Application Reference: 2026/0195

Site Address: 4 Holgate View, Brierley, Barnsley, S72 9HN

Introduction: This application seeks full planning permission for a single storey front extension to dwelling

PROPOSED FRONT ELEVATION (East)

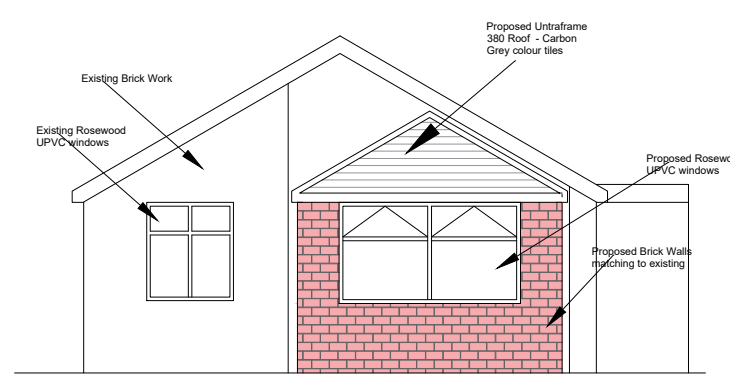
The actual design of the of the proposal is acceptable, despite the loss of a large proportion of the yellow stone cladding. As the proposal is to be constructed of matching brickwork, only a surround of yellow stone cladding would remain around the extension, thus supporting some of the dwelling's original character and retaining some similarity with the adjacent neighbouring dwelling.

The proposed hipped roof although not a match to the original style of roof, would follow the existing roof line of the front elevation. The height of the eaves and roof at approximately 2.40m and 3.46m respectively are acceptable in terms of scale, and comparison to the original dwelling, which features a maximum ridge height 4.46m. In addition to the matching brickwork, the proposed extension would feature two skylights on the side elevations of the roof, and branded Ultraroot Slate [brand name, not material) Carbon Grey coloured tiles. These appeared to be the best option of colours provided to match the existing roof.

Confirmation of proposed materials of a similar appearance to the original dwelling was sought and confirmed by the applicant's agent.

PROPOSED GROUND FLOOR PLAN

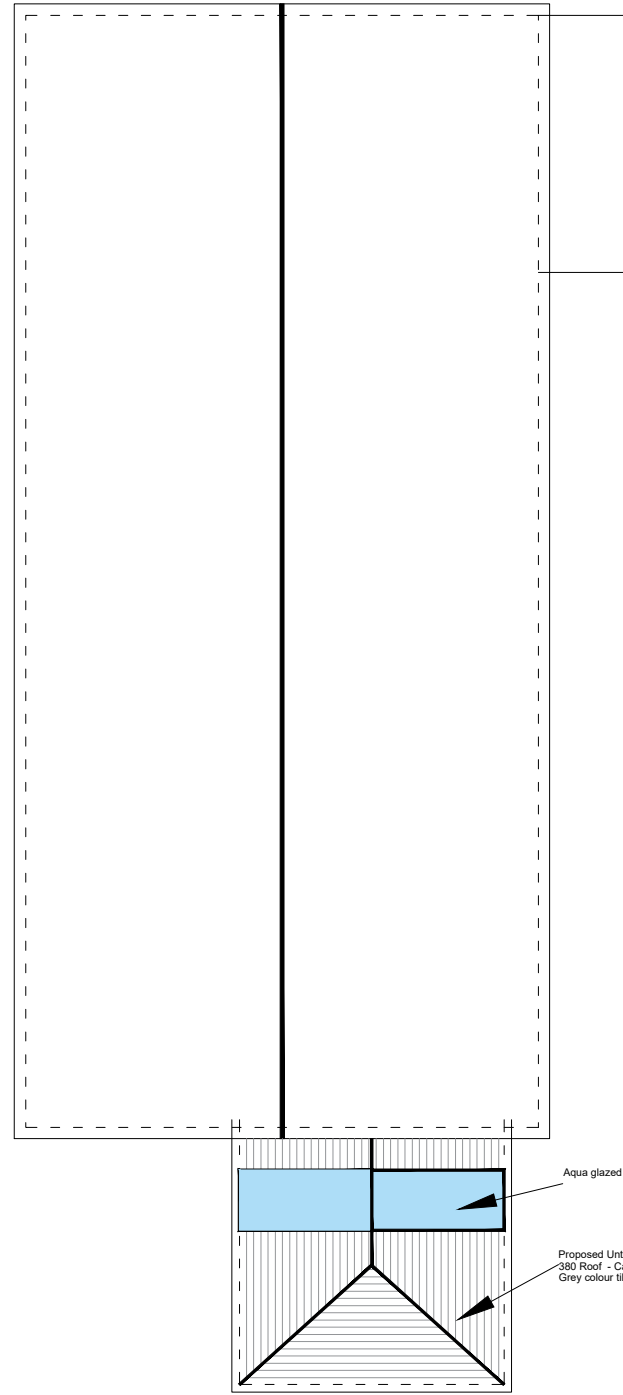
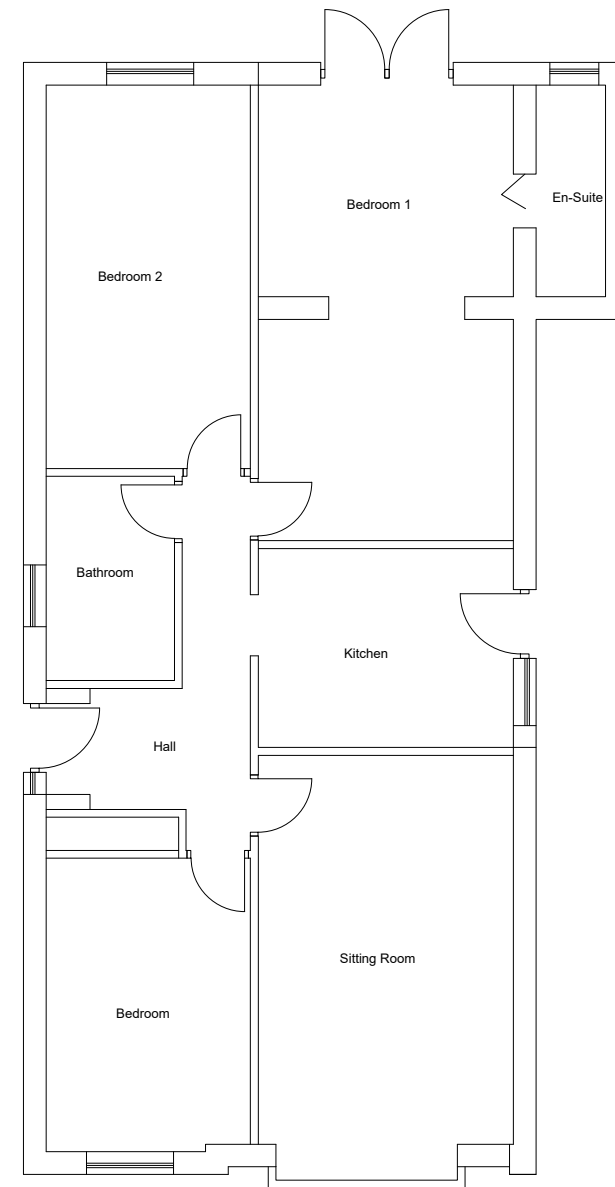
The proposed plans indicate a proposed front extension with measurements of 3.5m for the front projection and an equal 3.5m for width, although on the plans the front projection is measured at 3.4m, although this may be software error. Using the indicated measurements of 3.5m by 3.5m, providing a footprint of approximately 12.25 sqm is at the same time a modest size for an extension, but a relatively large front extension, especially the 3.5m projection. Some mitigation for its location arises from the fact the neighbouring dwelling of No2 is set further forward than the application dwelling, resulting in the extension only marginally exceeding the building line of No2.
